Re: Brewer Oil
3208 Richmond Drive NE
Traffic Circulation Layout

This is a response letter to the letter from you dated July 20, 2021. I will respond with the numbering you used for the comments:

A1.1
TCL

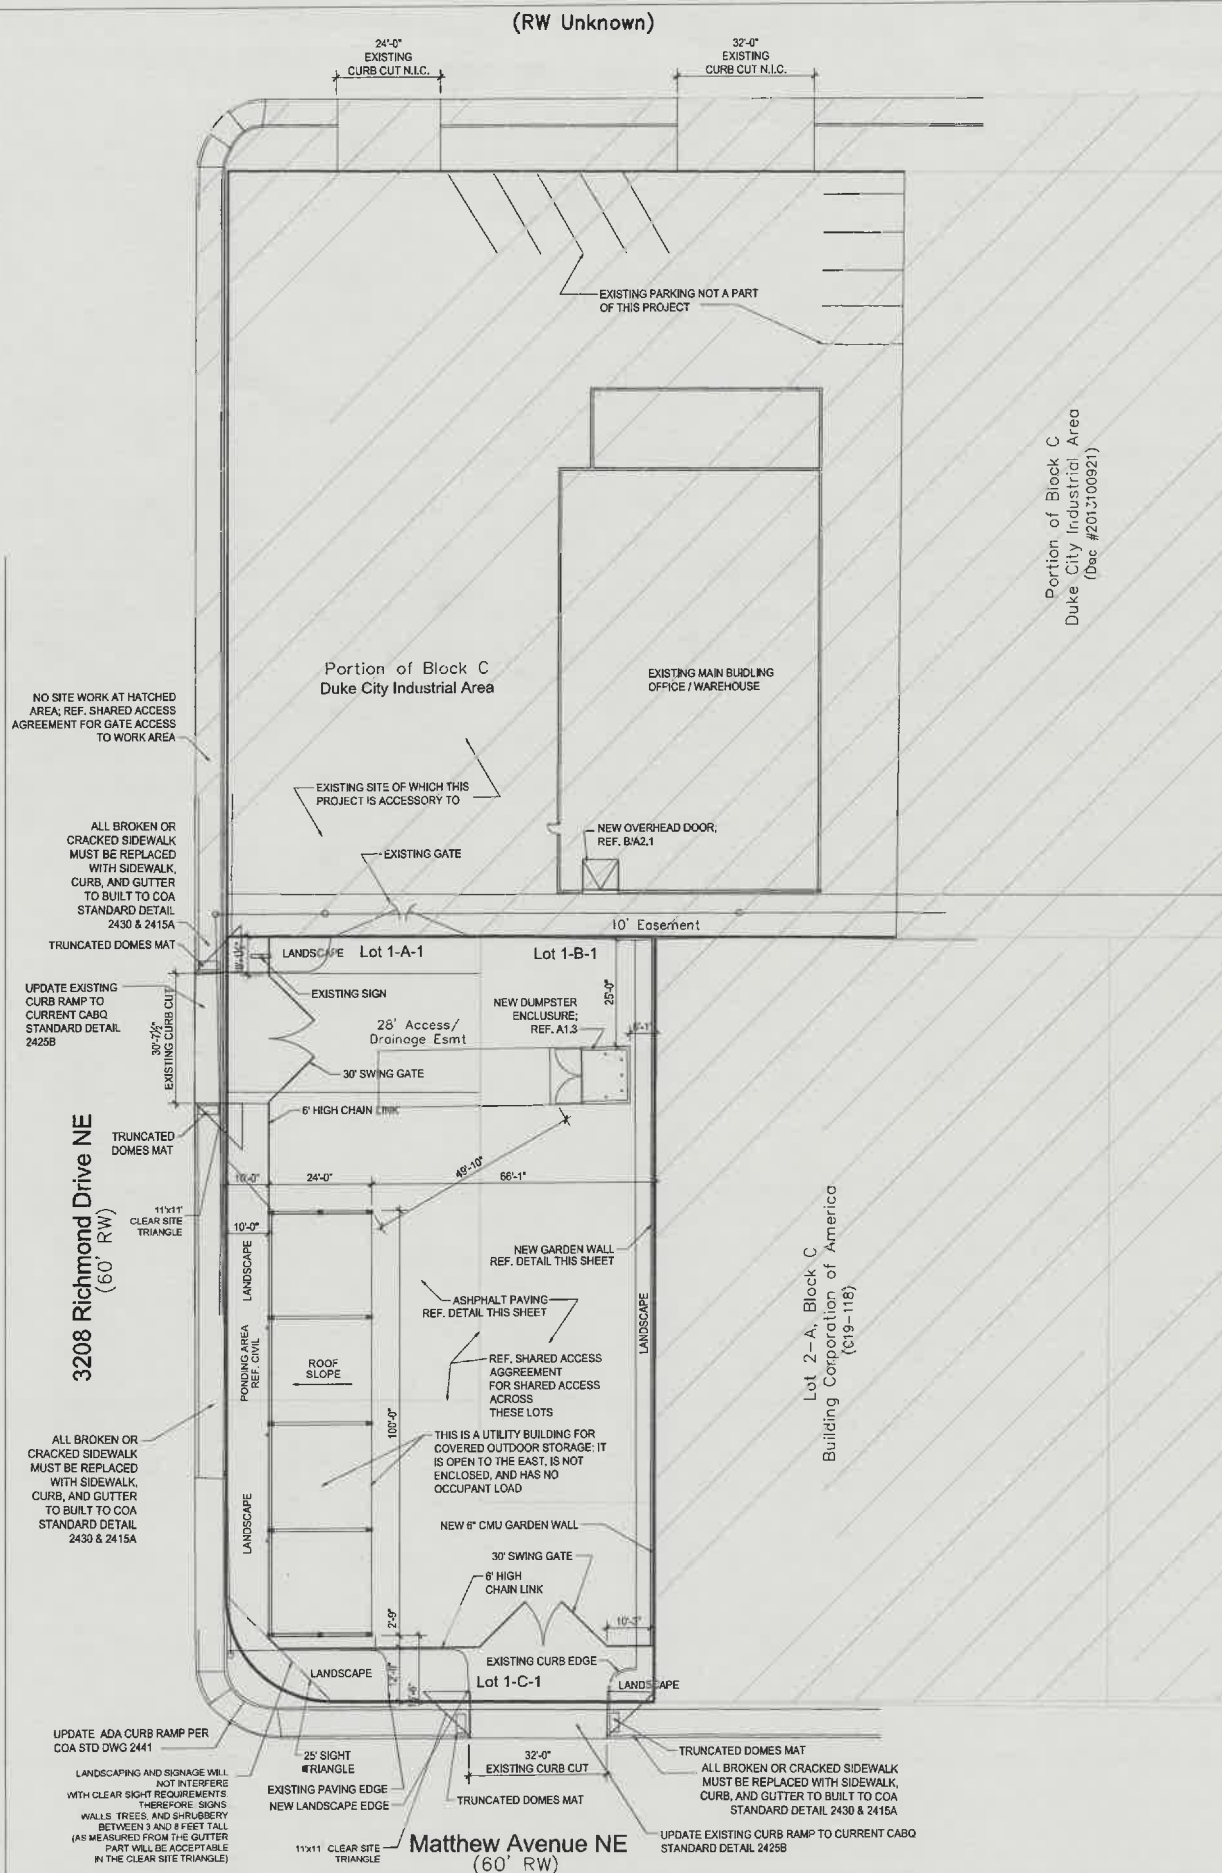
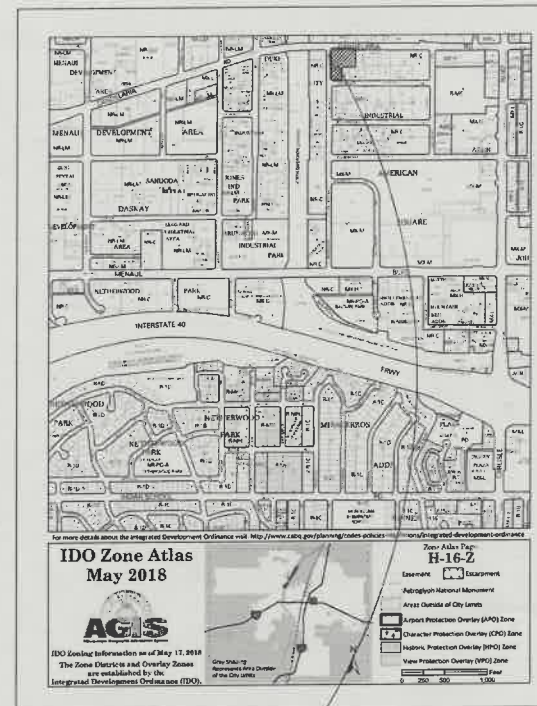
2. This is updated on the site plan.
3. Apologies. Upon investigation I learned it was a drafting error when attempting to show the existing adjacent conditions. You can see on sheet A1.0 (attached with the resubmittal) the edge of curb was much farther north than what we showed. The drawing has been corrected to show actual conditions.

7. Dimensions have been added for driveways and drive aisles.
8. Please reference response #1.
9. Please reference response #1.
10. Please reference response #1.

18. This has been added to the drawing.
19. This is shown on the drawing. There are interior lot lines per shared access agreement that has been noted. The only structures in this project is the open sided storage building and the new dumpster. Everything else is open paving except where noted as landscape.

20. The only curved radii shown is the existing corner at Richmond and Matthew. That corner has been noted to COA standard drawing.
21. Please reference response #1.
